**Section 96A of the Town & Country Planning Act 1990 (as amended)
Town and Country Planning (Development Management Procedure) (England) Order 2015 (as amended) - Article 10**

Non-material amendment following the grant of reference EP/148/18/HH for the addition of 1 No. round 600mm diameter white PVCu window on first floor east elevation.

86 Sea Road East Preston

PROPOSED EAST ELEVATION 1:100

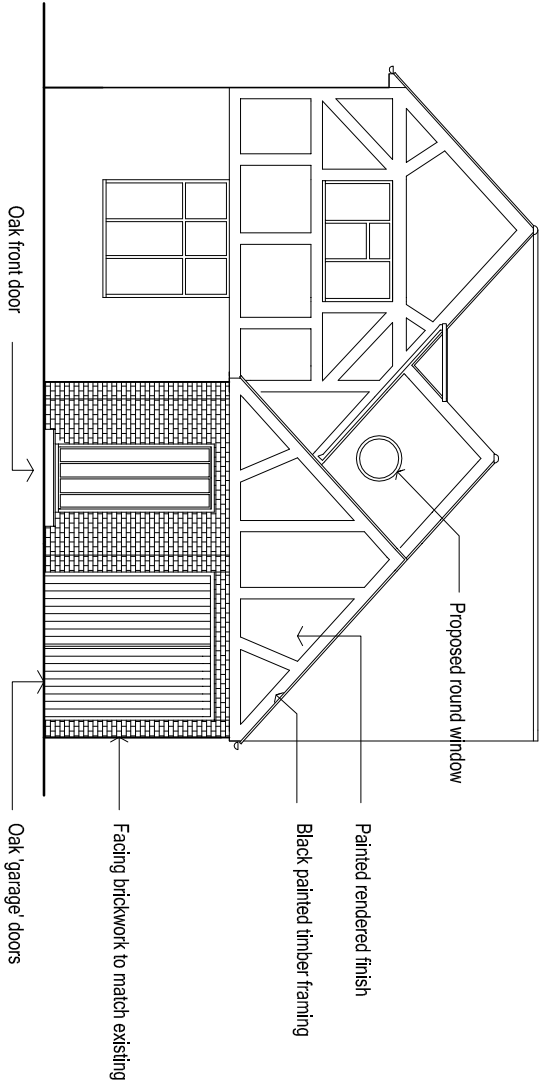
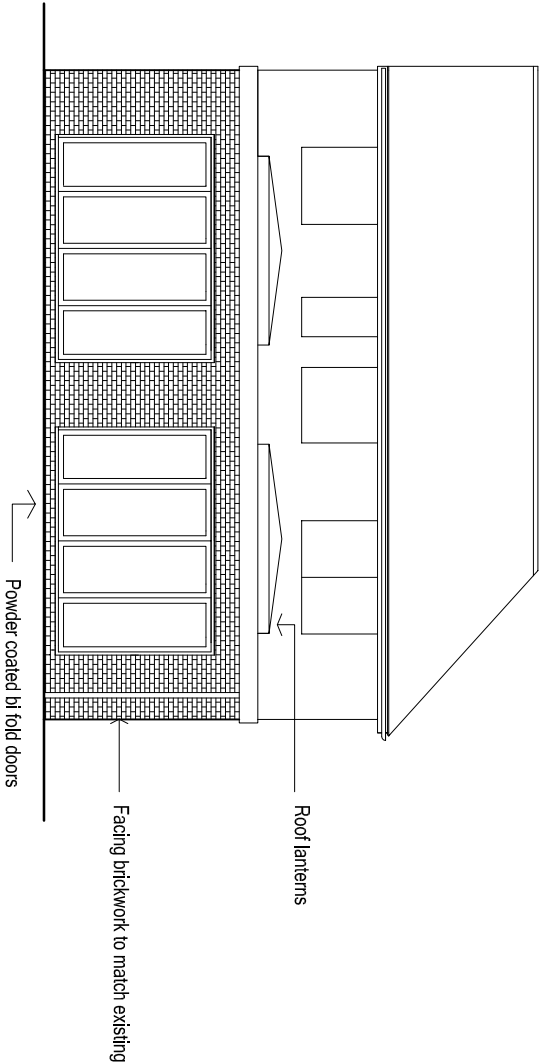
The proposed circular window introduces a wholly new element into this row of still very similar looking houses. The features of the front elevations of these properties are almost wholly angular, emphasised by straight timber lines. This proposal will, this council believes, have a negative impact upon the streetscene. A carefully-positioned rectangular window would be in keeping with the other front elevation windows in this line of properties.
